Planning Inspectorate

Our Ref: EN020027

Application by National Grid Electricity Transmission (NGET) for an order granting development consent for the Norwich to Tilbury project

Advice following issue of decision to accept the application for examination

Revision:
A

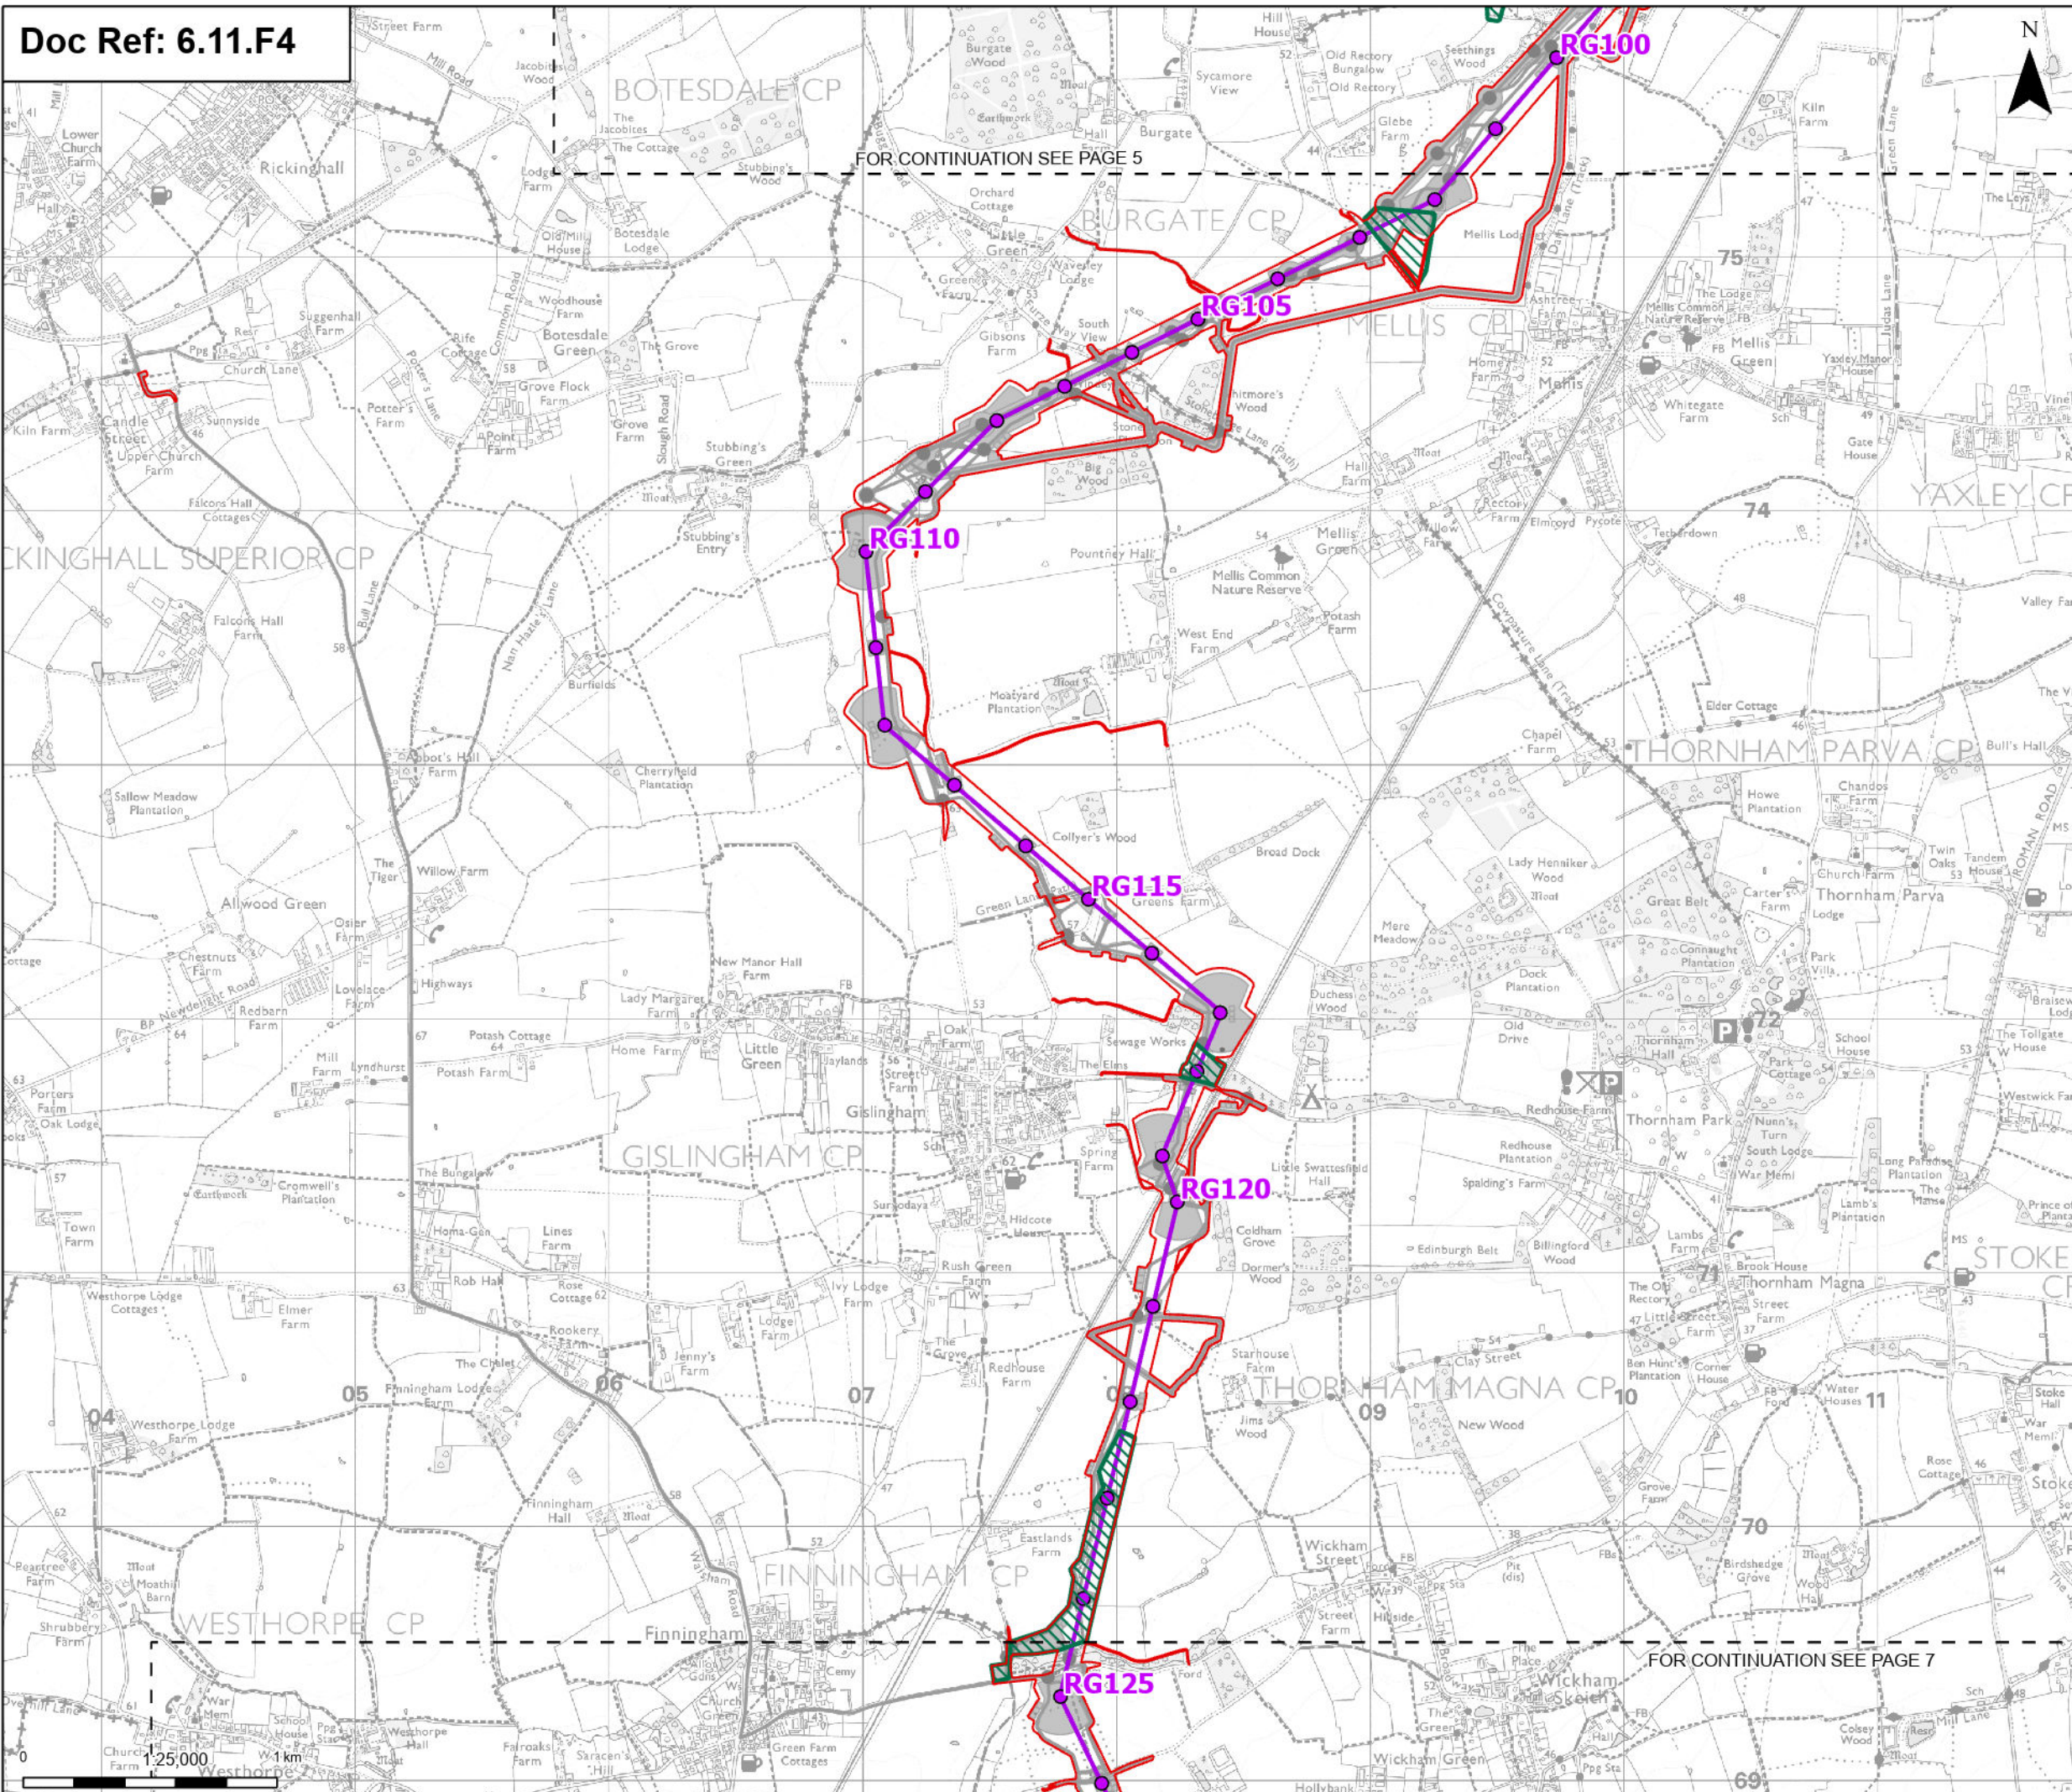
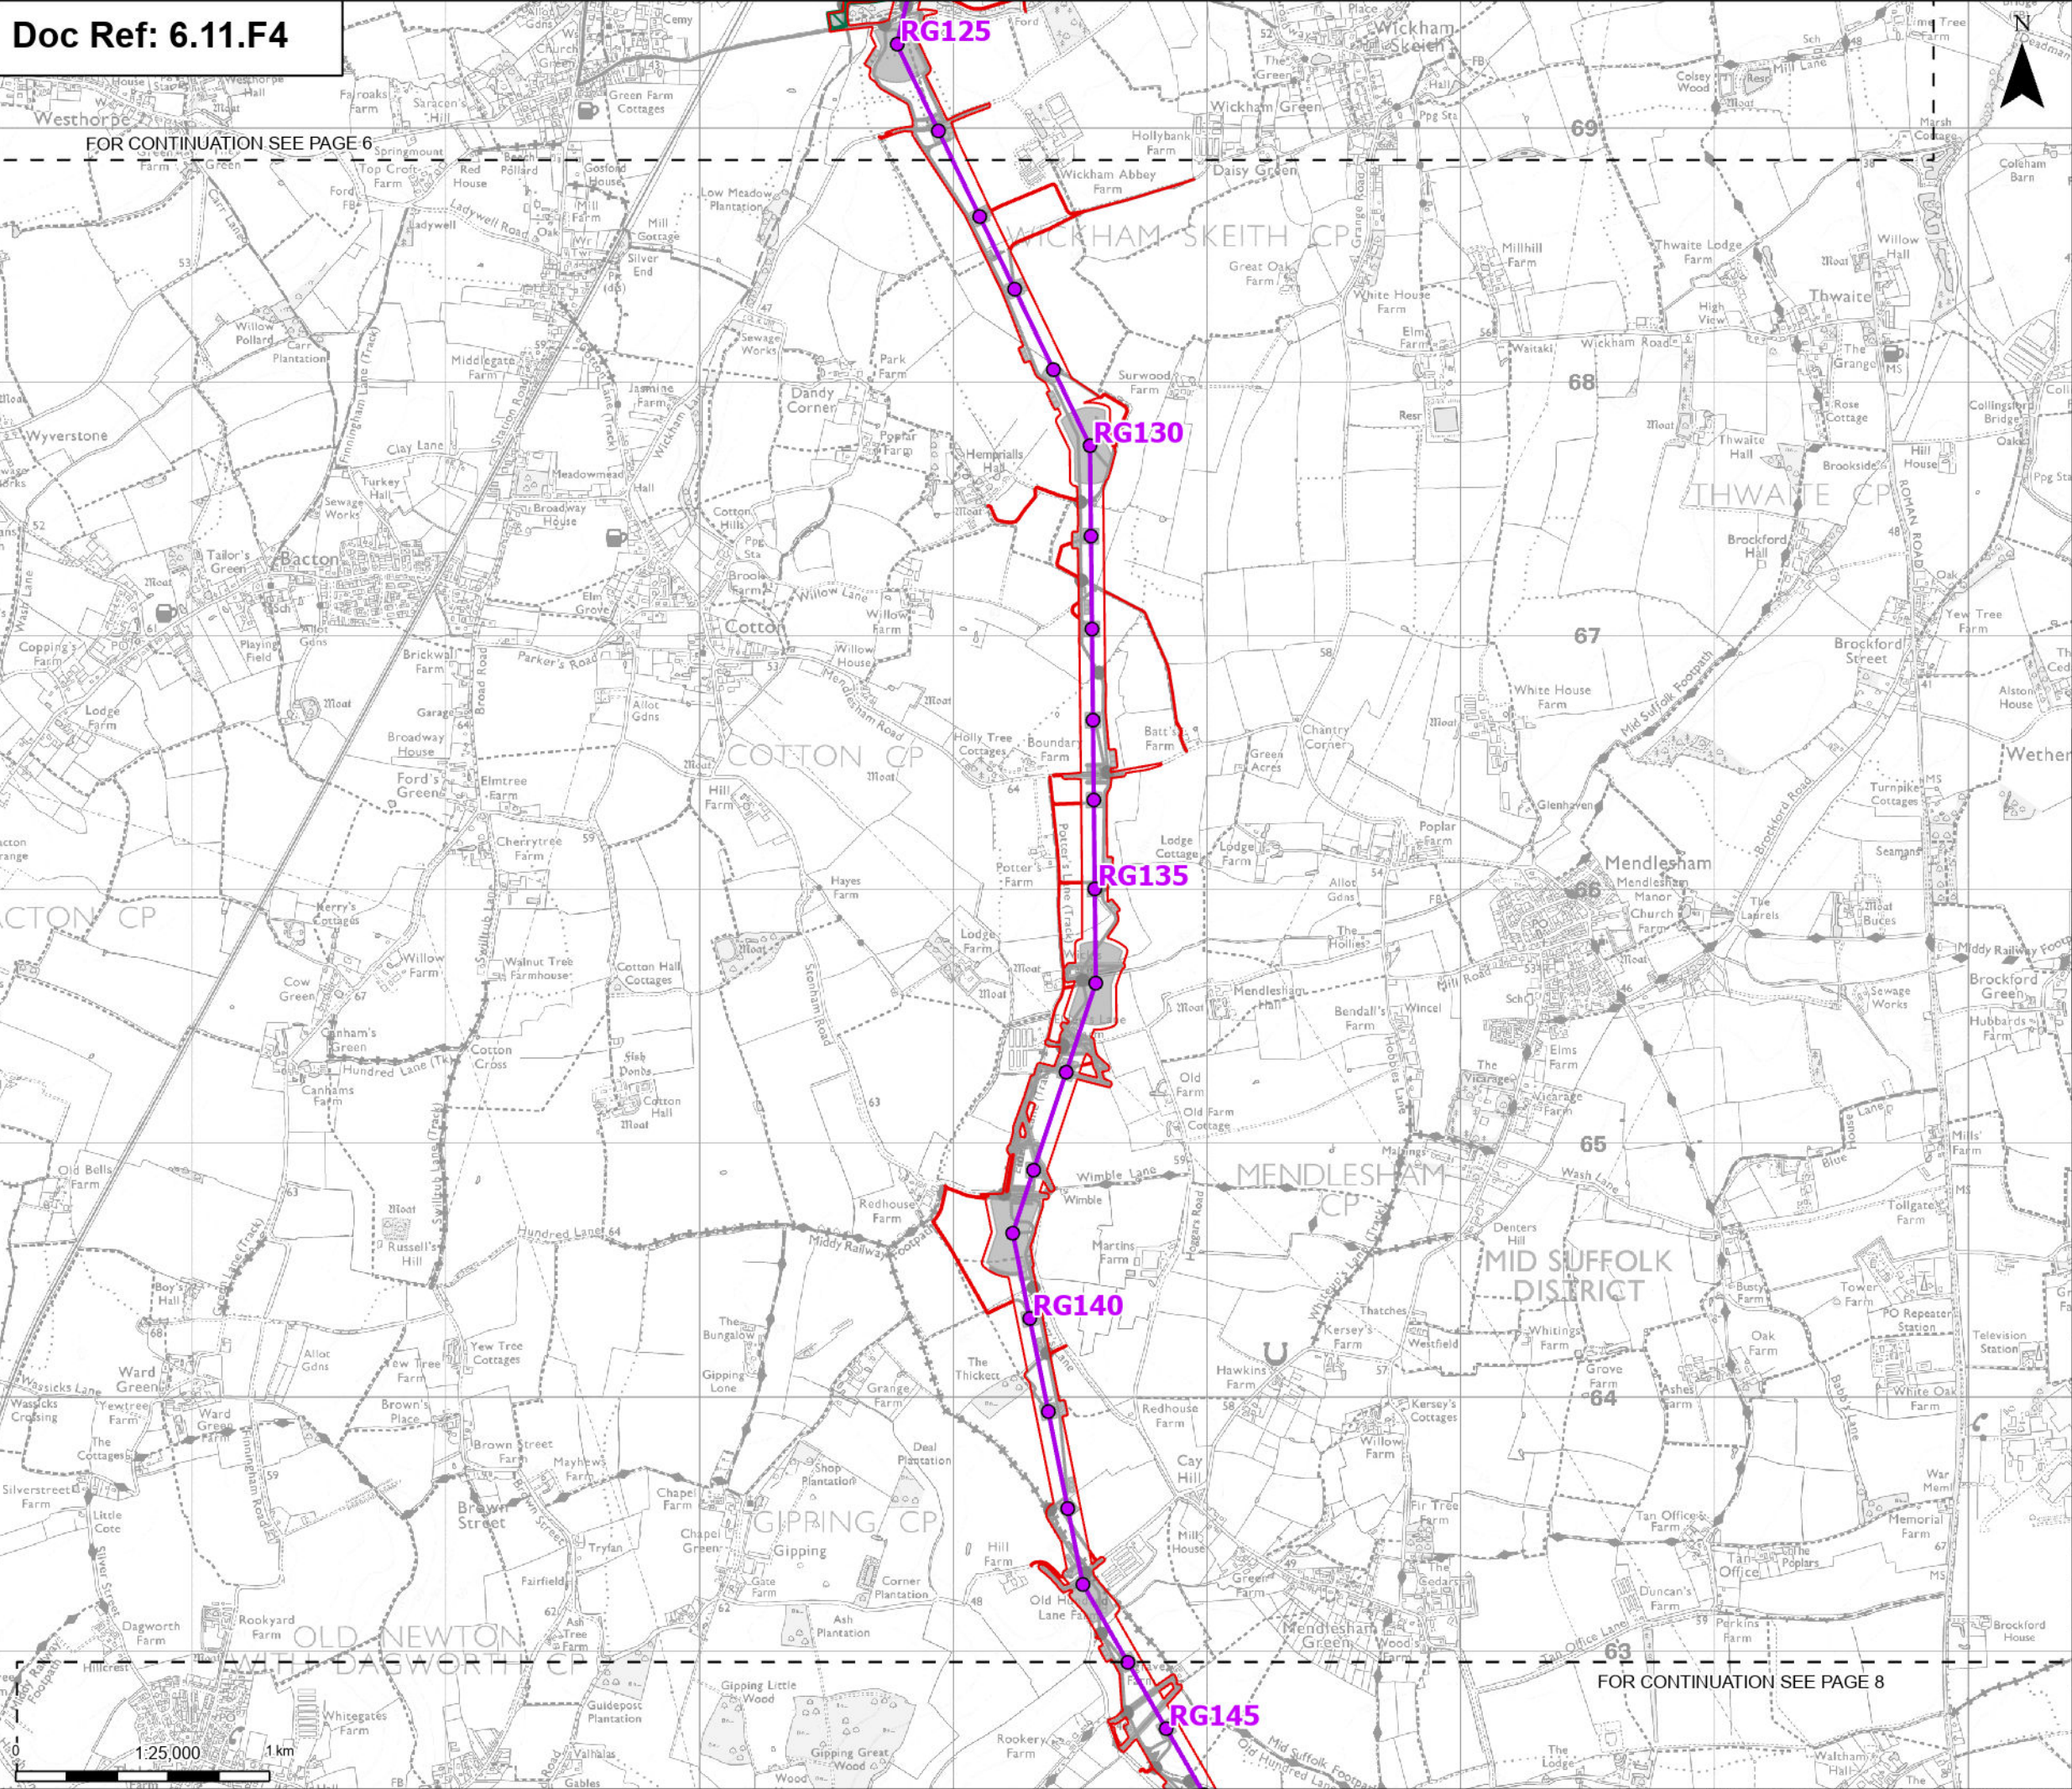
The pre-application engagement with Historic England and the relevant Councils since November 2023 regarding archaeological evaluation fieldwork is noted by the Planning Inspectorate, including the agreement of certain areas as ‘priority areas’ where geophysical surveys commenced in summer 2023 and trial trenching since Autumn 2024. The results of this fieldwork are contained within Appendices 11.3, 11.4, and 11.5 and incorporated in Section 11.5 to inform the baseline for assessment. It is noted that archaeological work on these areas and upon ‘phase 2 areas’ is ongoing and will continue into 2026, and that this approach has been agreed with the relevant statutory bodies. Table 11.2 of chapter 11 of the ES details these works to a certain degree, with a map of priority areas included in figure 11.4. It is noted that results from these further works is programmed to be submitted at various times: November 2025 prior to the start of the Examination; shared and agreed with Stakeholders early in 2026; and throughout 2026.

The Planning Inspectorate advises the applicant provides further clarification on such works in terms of details of the nature and location of the further works, and how and when the results will be submitted (see below regarding updates to the ES). It would also be beneficial if the results and analysis were submitted together where possible to avoid the drip feeding of information.
